Phone: 0300 123 6780
Email: developeras@lancashire.gov.uk
Your ref: 3/2026/0545
Our ref: 3/2026/0545/HDC/KW
Date: 19 August 2026

Location: Office Brows Barn The Brows Farm Higher Road Longridge PR3 2YX
Proposal: Proposed change of use of East Barn from Use Class E(c) to a mixed use (sui generis) to provide residential living accommodation and ancillary facilities associated with the existing holiday let accommodation.
Grid Ref: 362150 438383

Summary

No objection subject to conditions

| 0803/93           |        | Drawing No 04C |         |

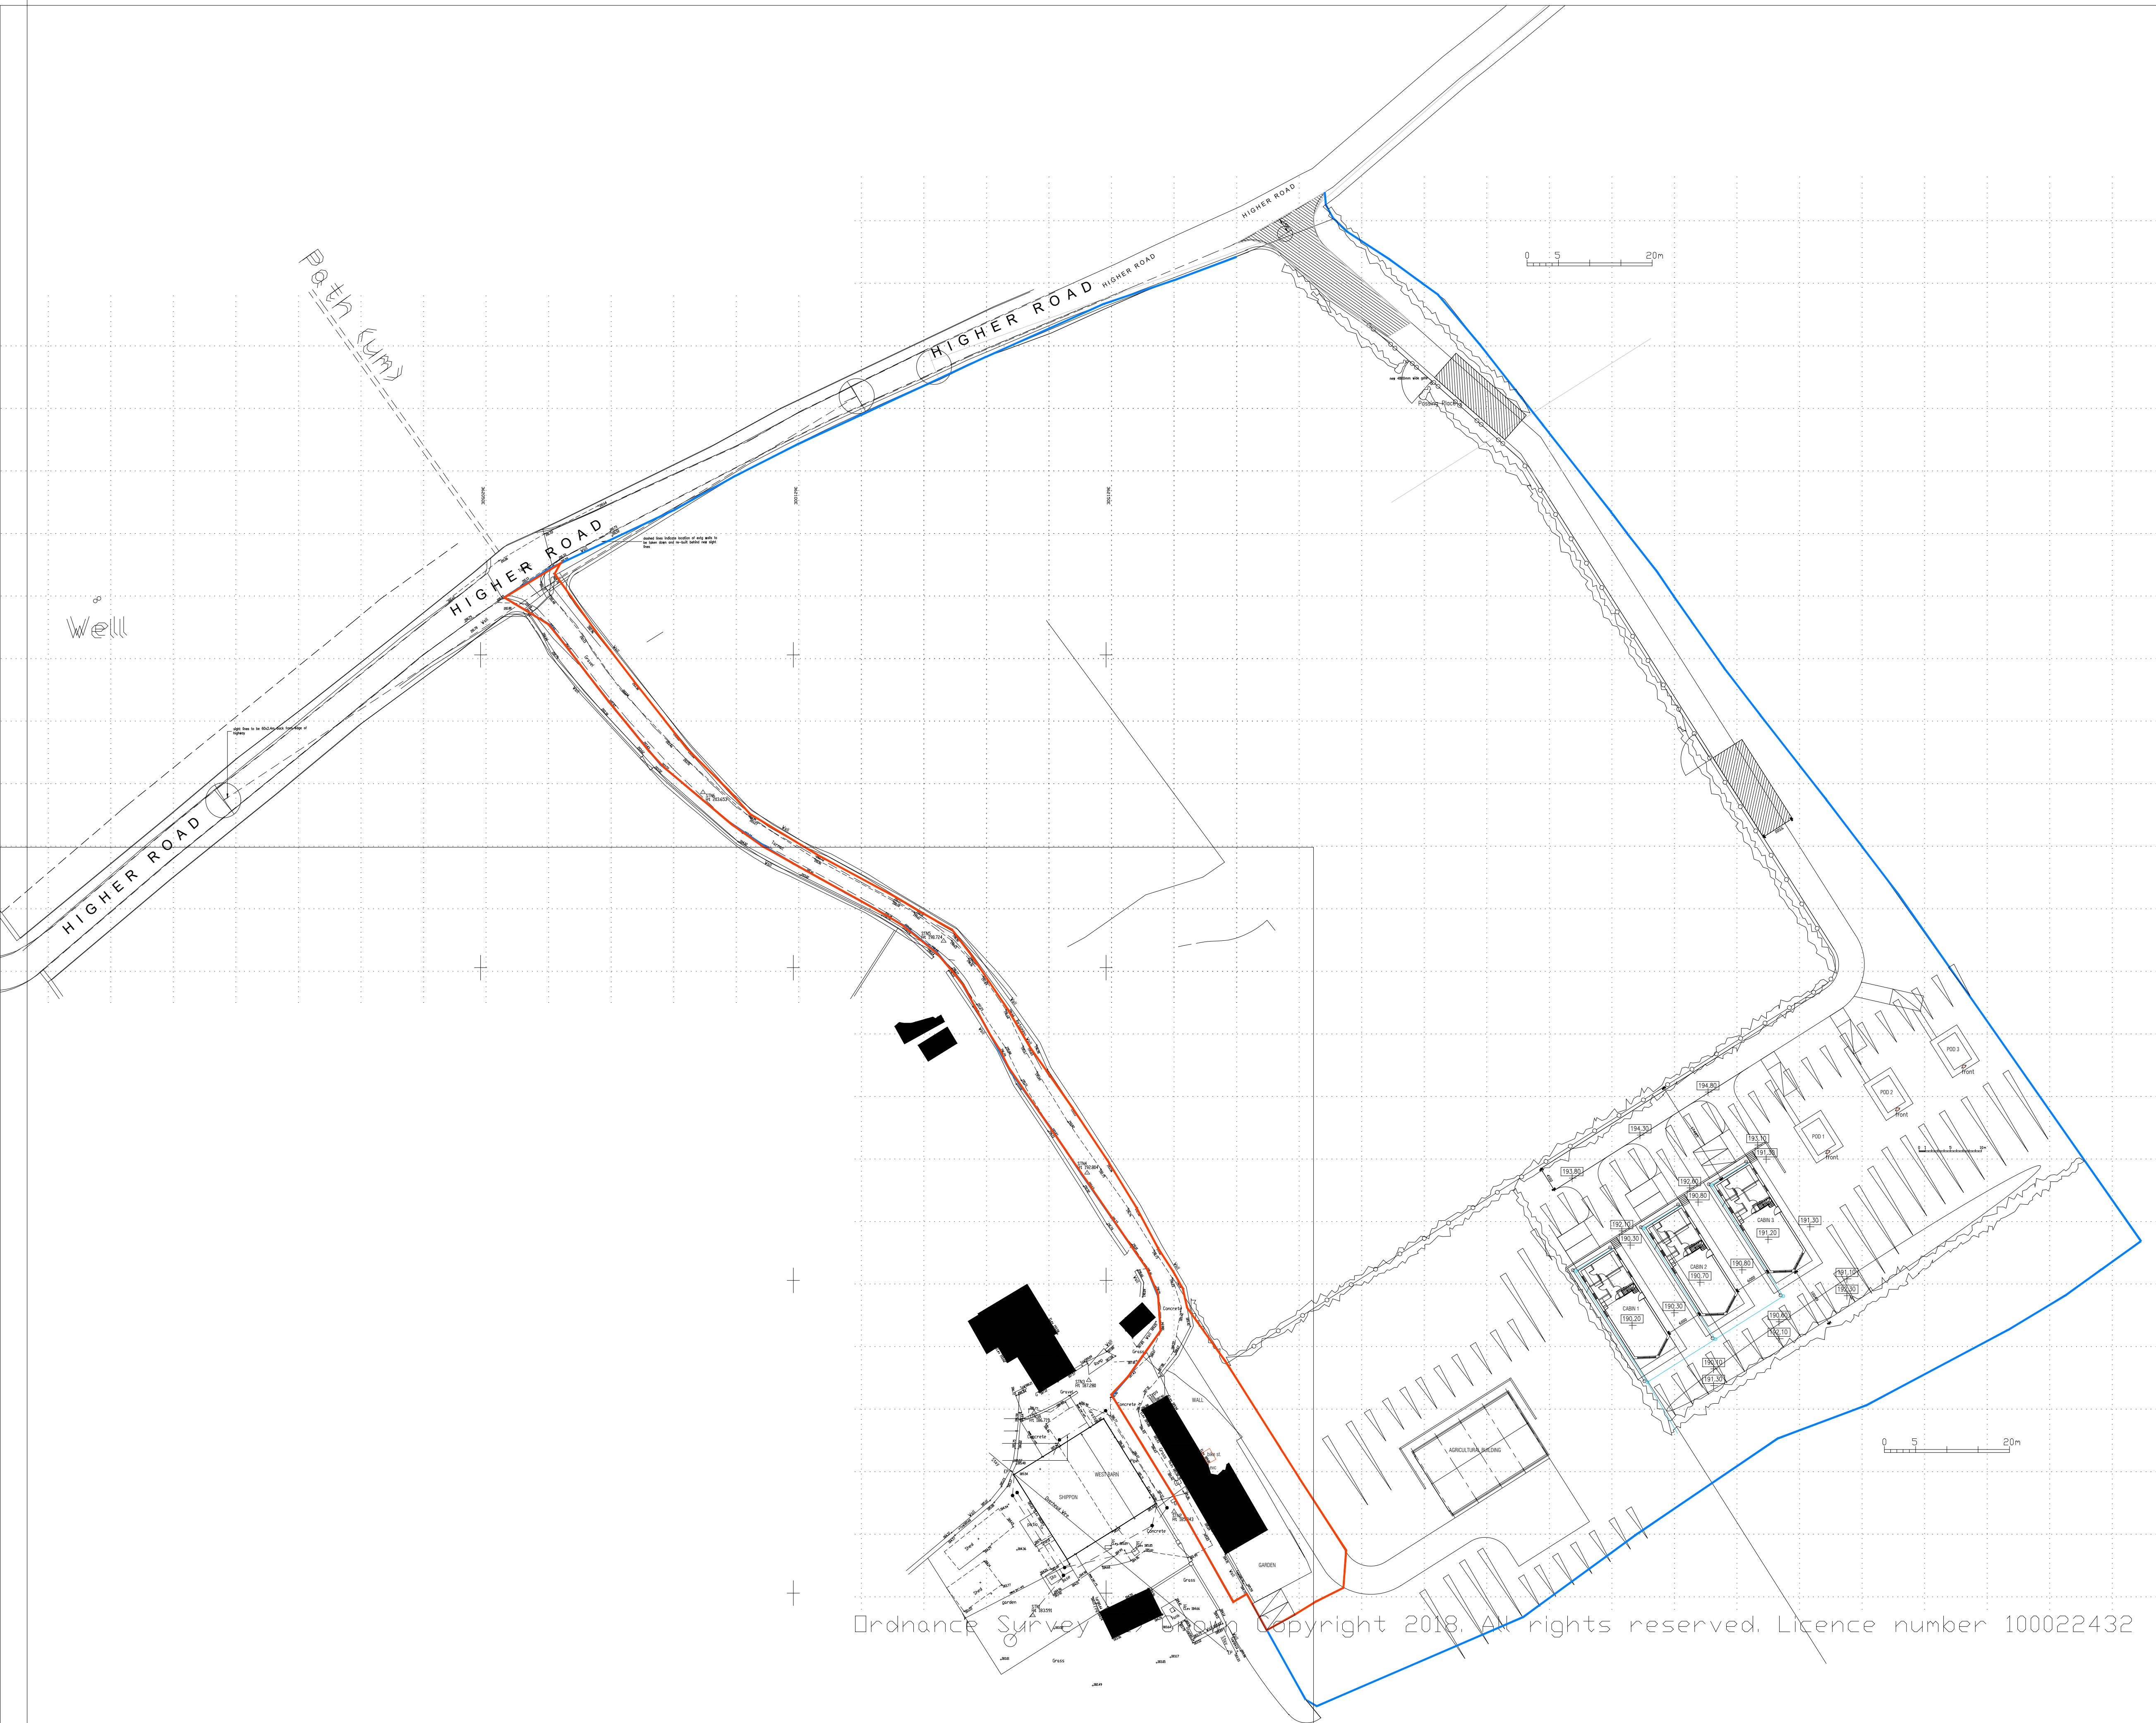
Additionally, due to the nature of the application, it is expected that secure cycle storage should be included within the site, alongside a charging point for electric vehicles to promote sustainable modes of transport. The DfT guidance regarding Electric Vehicle Charging in Residential and Non-residential buildings states charge points must have a minimum power rating output of 7kW and be fitted with a universal socket that can charge all types of electric vehicles.

Job/Schema Number		Drawing Number	
0803/93		Drawing No 04 B	
Scale	Date	Drawn	Checked
1/500th	June 26	a.t.l-h.

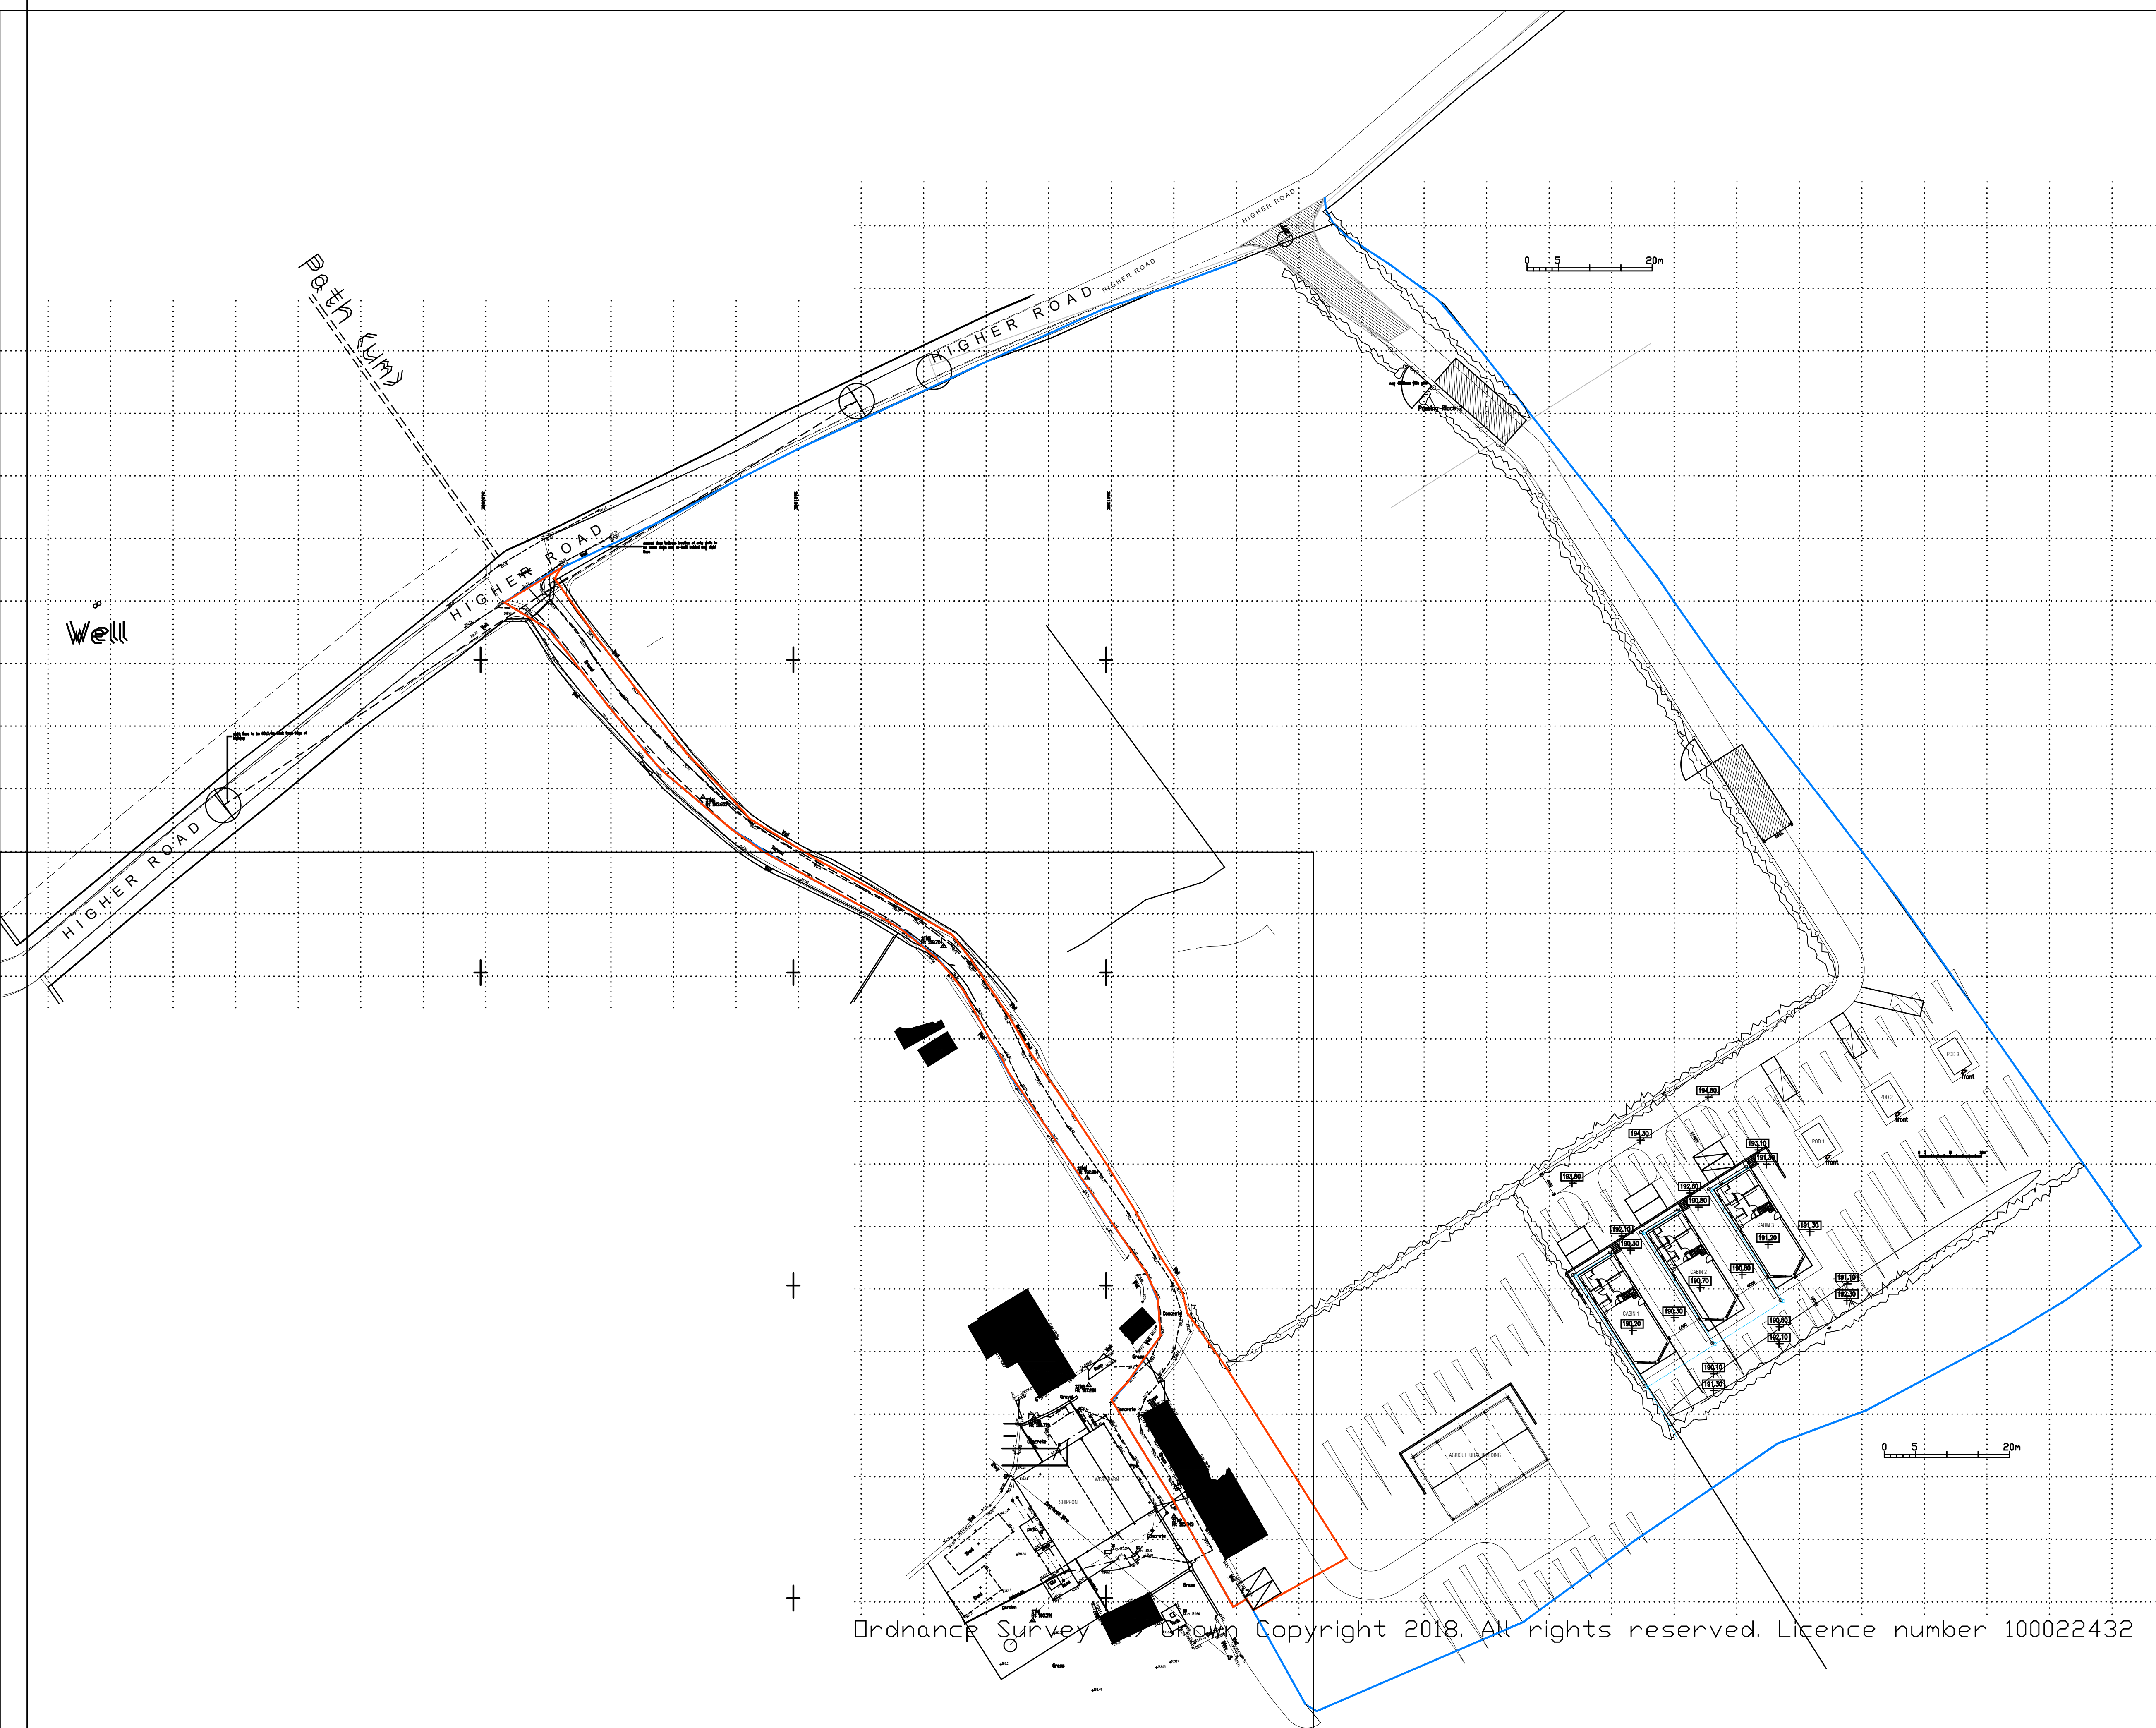
The LHA have reviewed drawing number 0 4 B titled Proposed Site Plan and are aware that the dwelling complies with the parking standards as defined in the Joint Lancashire Structure Plan. There is also room to turn within the site, allowing for ingress and egress in a forward gear.

2. Secure cycle storage facility suitable for two bicycles shall be provided within the site.
